Subject: FW: Crete Nursery, Dappers Lane, Angmering - Culvert - Condition 10

RE: Land Drainage Works – Development at Crete Nursery, Dappers Lane, Angmering

Connection to culverted watercourse, and provision of trash screen at existing headwall, at Crete Nursery, Dappers Lane, Angmering

Description of works: Connection to existing 450mm
culvert with 150mm diameter discharge from sewage
treatment plant. Provision of cranked trash screen to
suit 450mm diameter culvert at existing headwall.

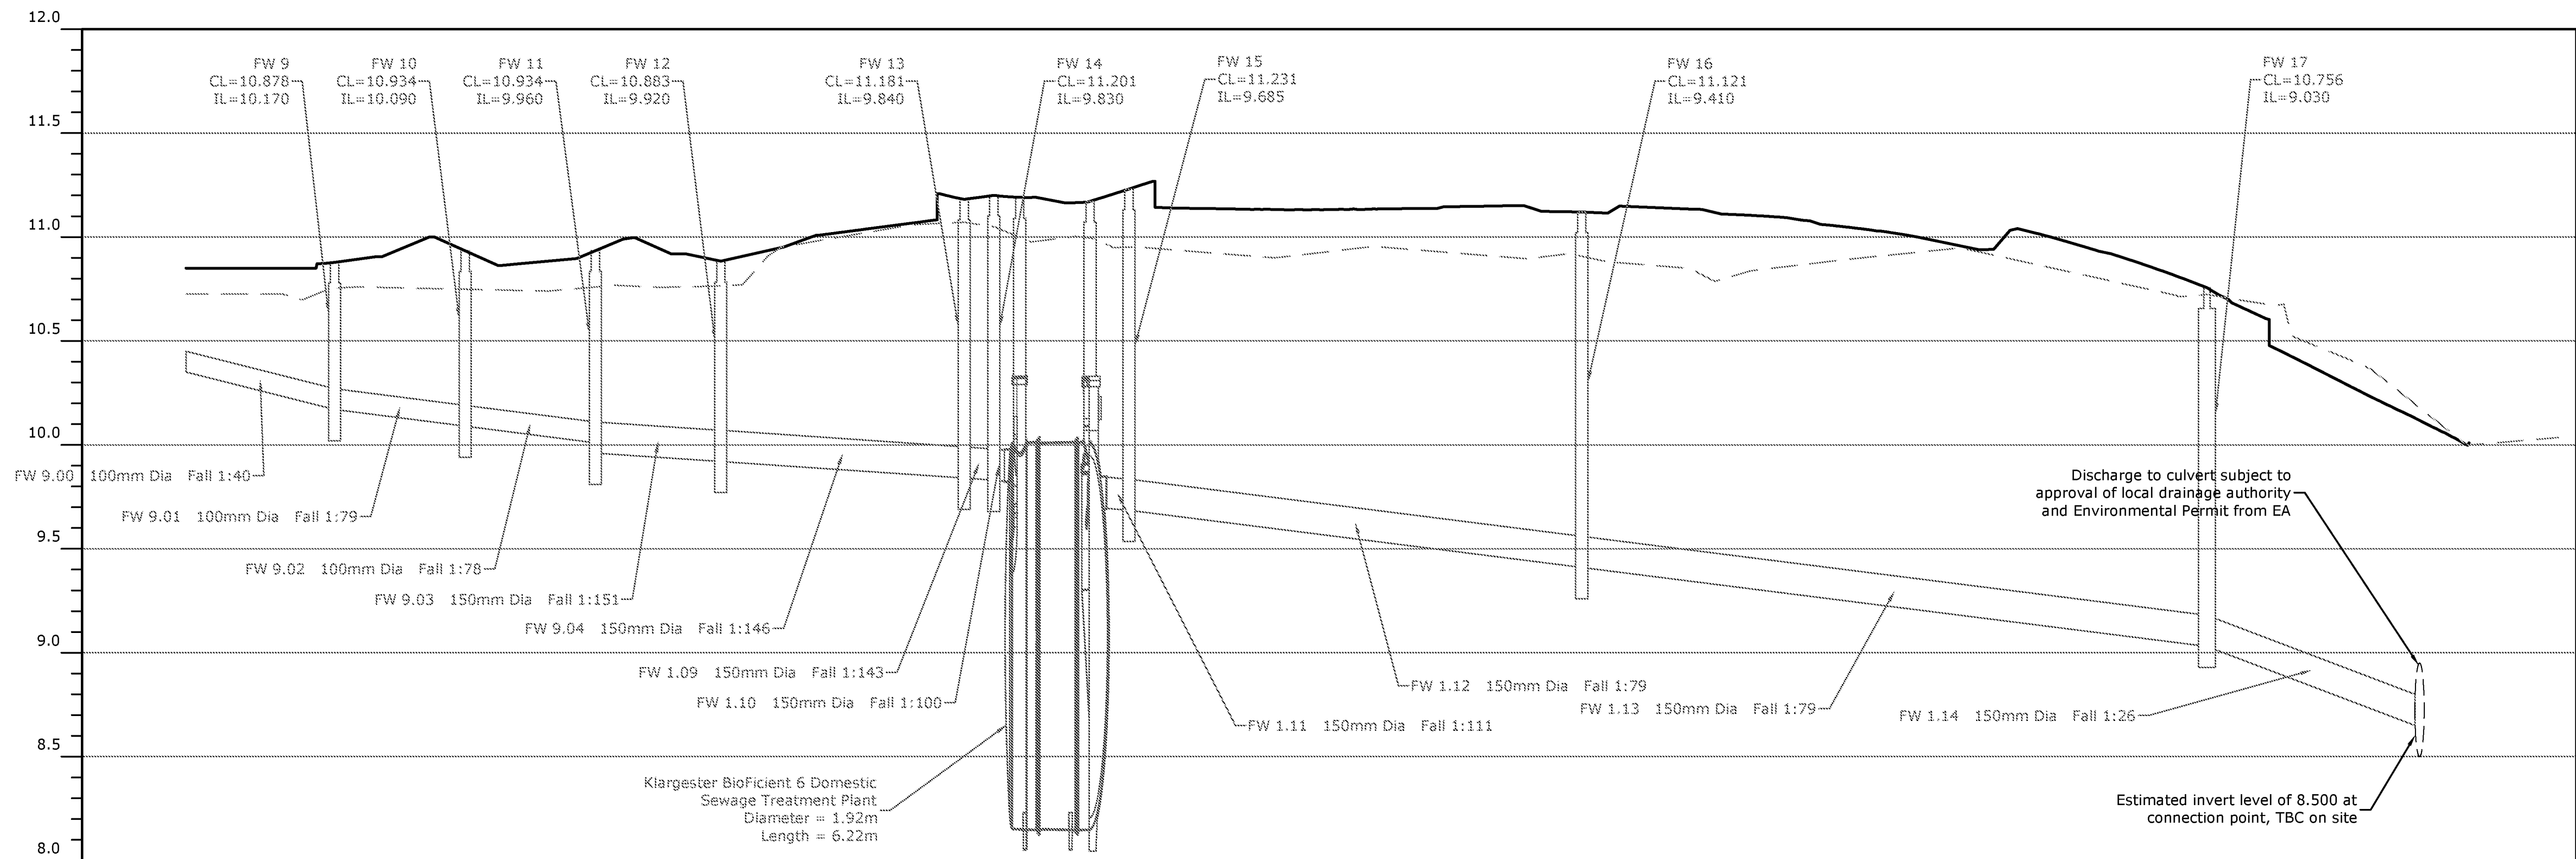
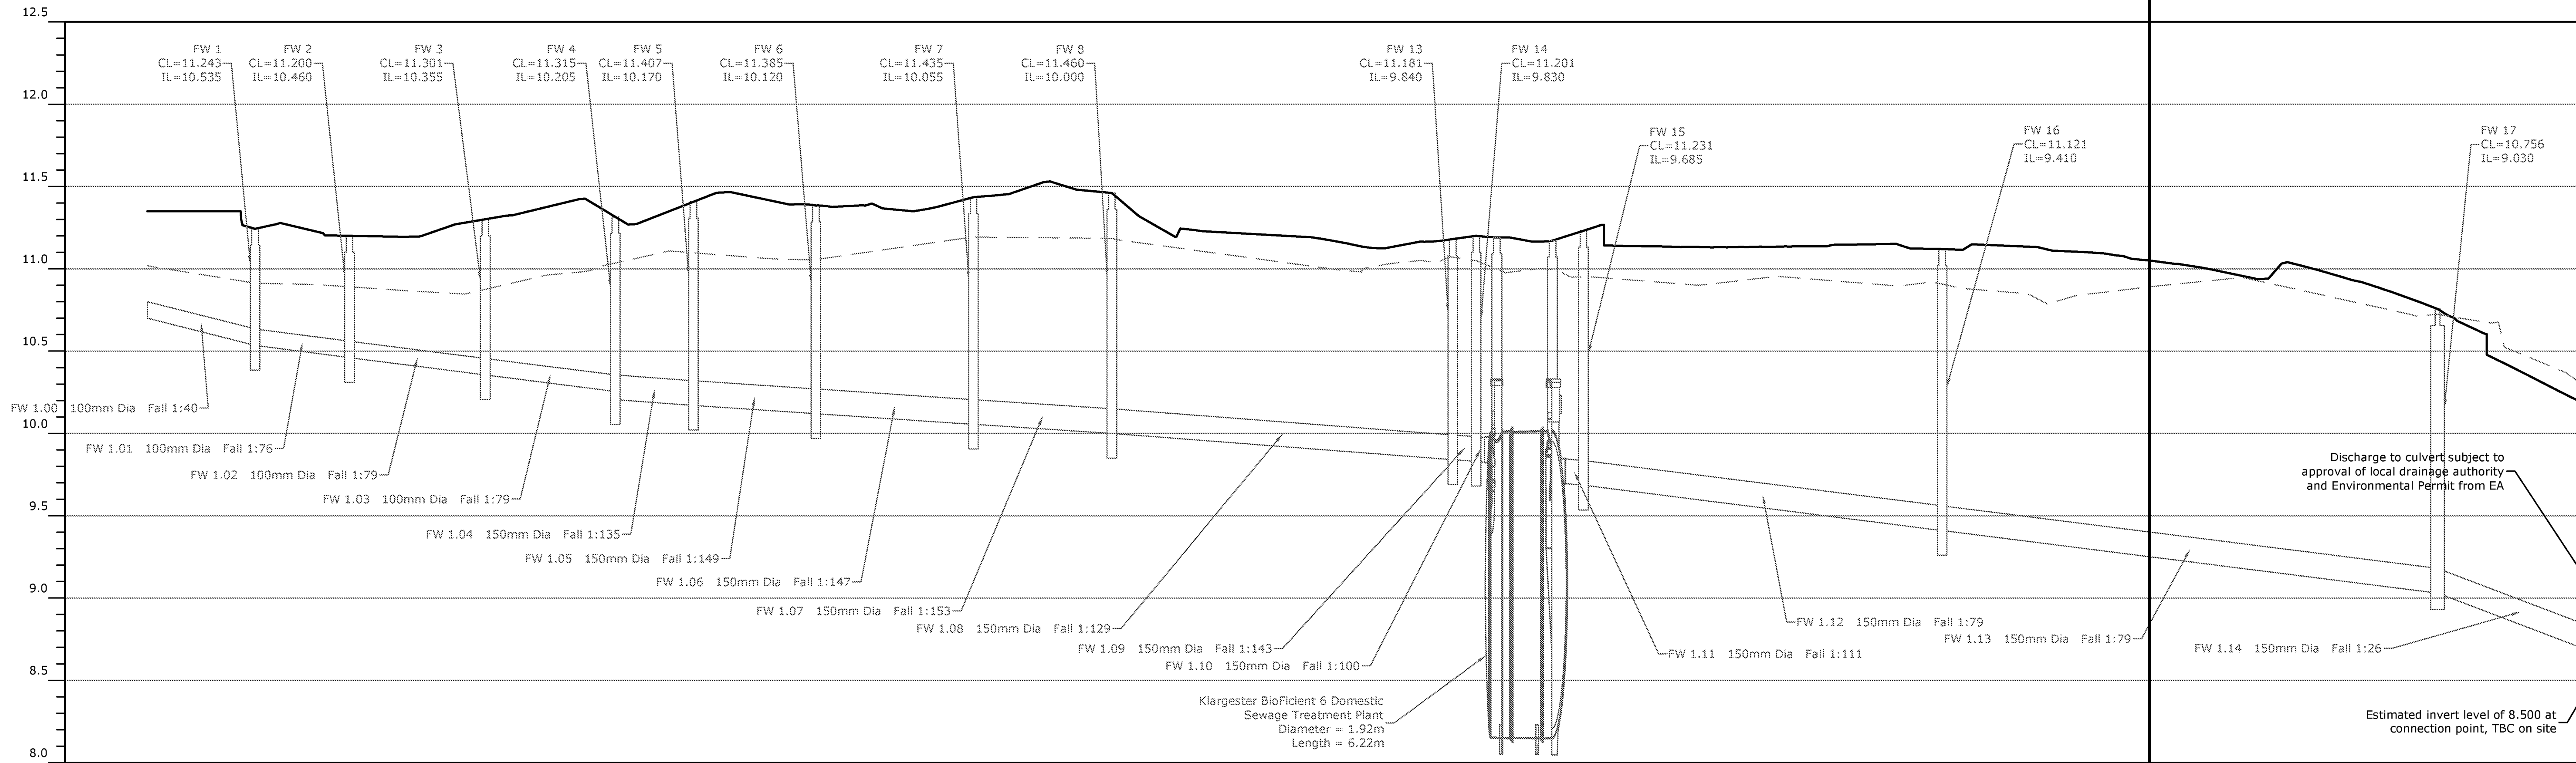
In respect to the headwall repairs and trash screen proposal – that is fine. Please add suitable notes – I suggest that the note mentions that the works need to be agreed with the ADC engineer. Also, the trash screen will need to be a cranked version – see <https://www.althon.co.uk/products/450mm-sloped-trash-screen-sides-45/detail/> for example. Please specify the detail/manufacture on the drawing.

Thanks for your comments, we have added these notes to the drawing, please find enclosed.

Drg no. 191183/500/01 Rev K, 191183/510/01 Rev D, 191183/520/01 Rev C, 8000301 Rev A
